Marine  
Management  
Organisation

**Your Reference:** TR030003  
**Our Planning Inspectorate  
Reference:** 20010091  
**Our Internal Reference:**  
DCO/2017/00001

16 August 2018

**RE: TILBURY2 – SECTION 89 AND THE INFRASTRUCTURE PLANNING  
(EXAMINATION PROCEDURE) RULES 2010: EXAMINING AUTHORITY’S “RULE 8  
LETTER”**

TILBURY 2 DOCUMENT REF: POTLL/T2/EX/195

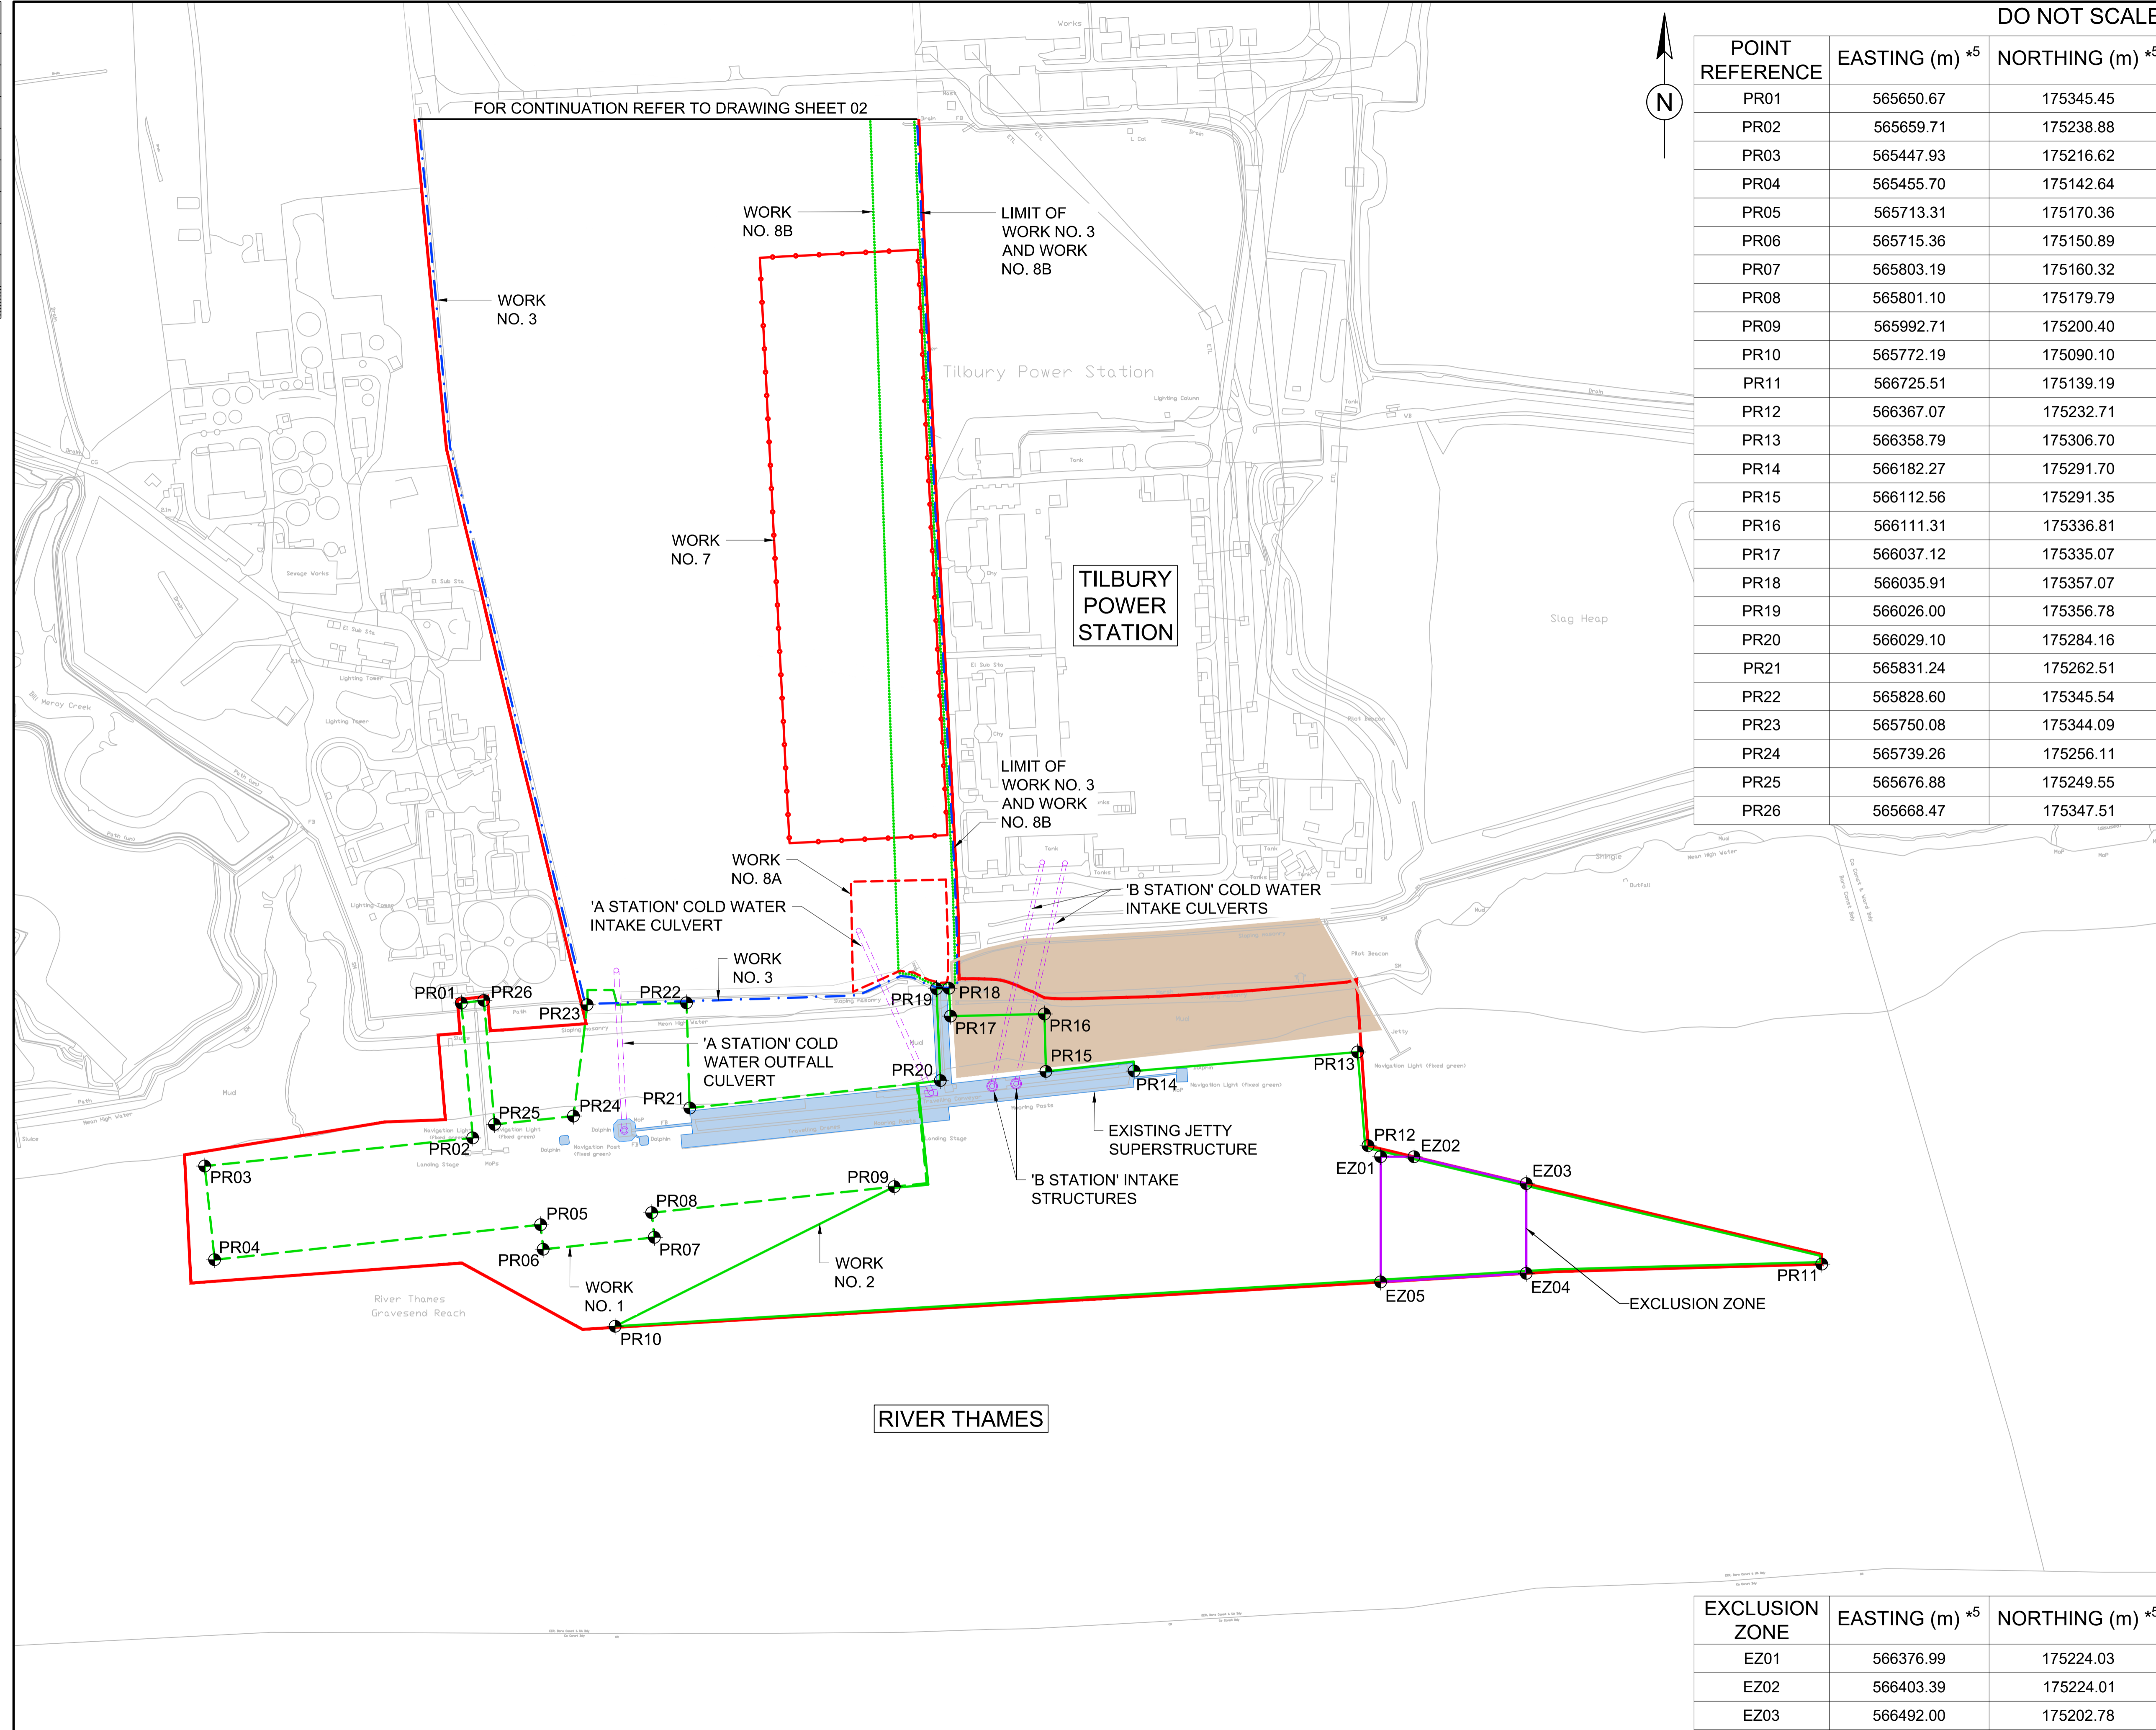
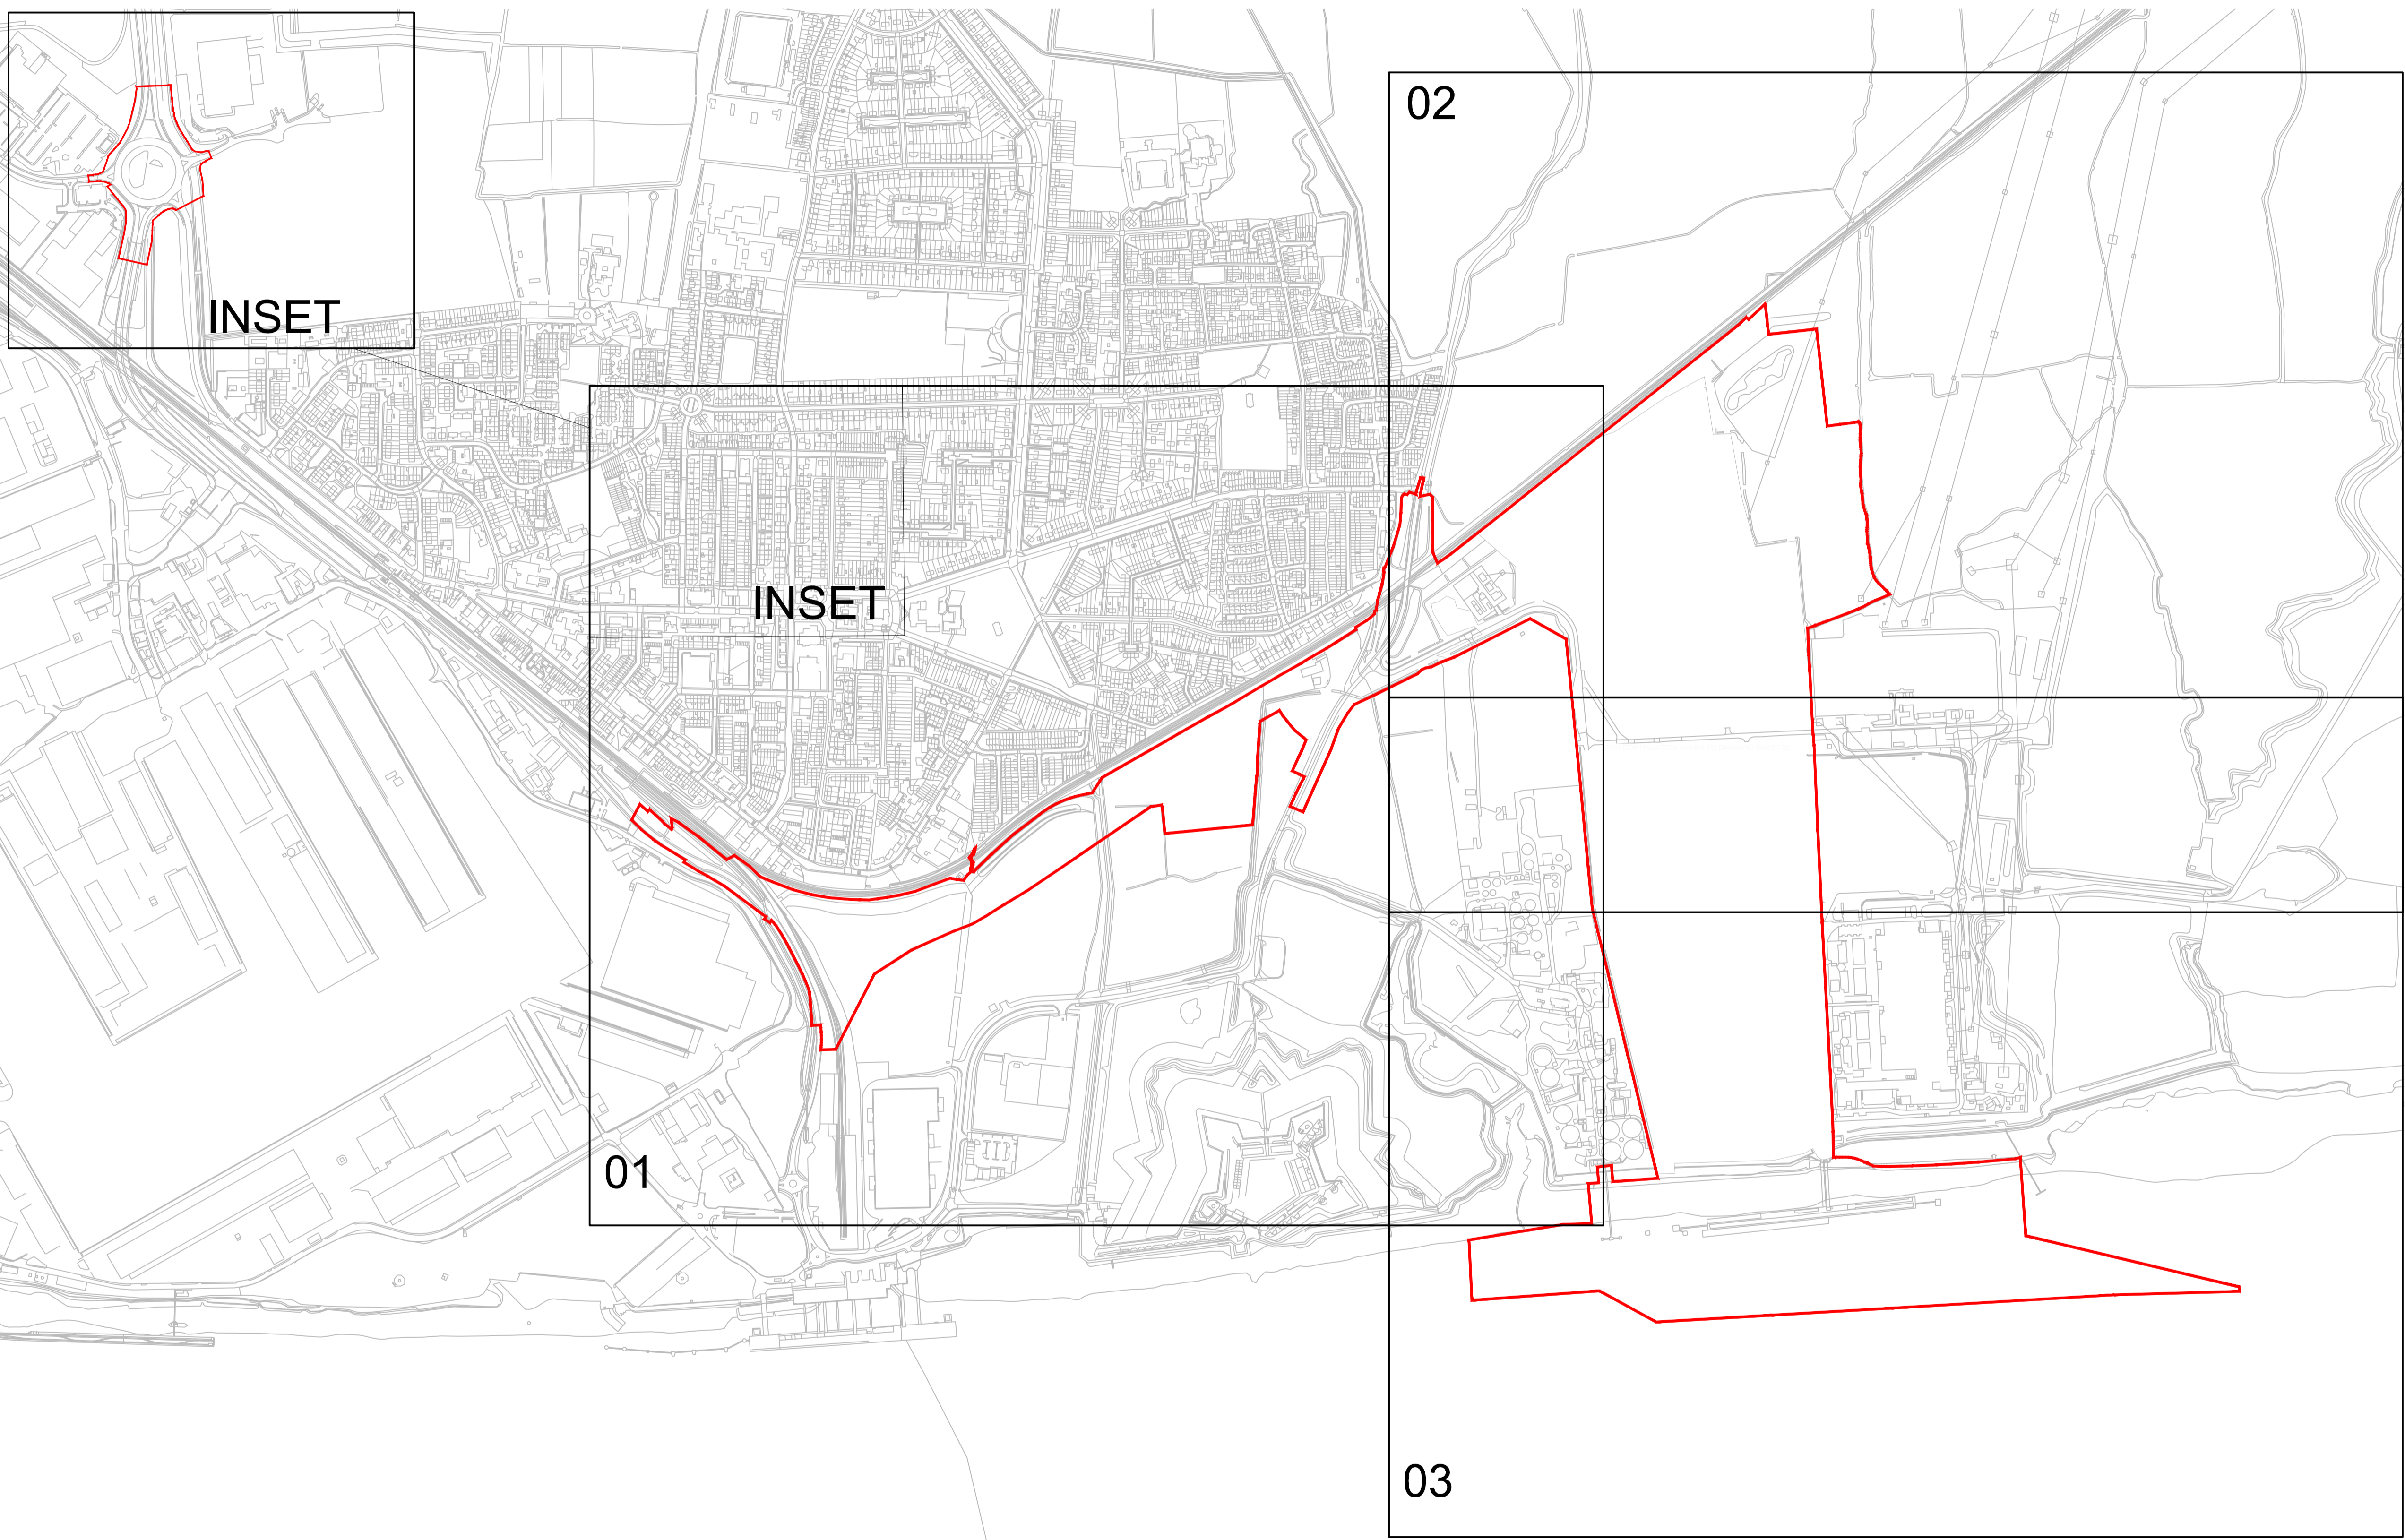
1.1.7. The MMO requests that amendments are made to show the entire order limits in the document Work Plans V3 [POTLL/T2/EX/195]. An updated version of this document was not provided as part of the deadline 6 responses.
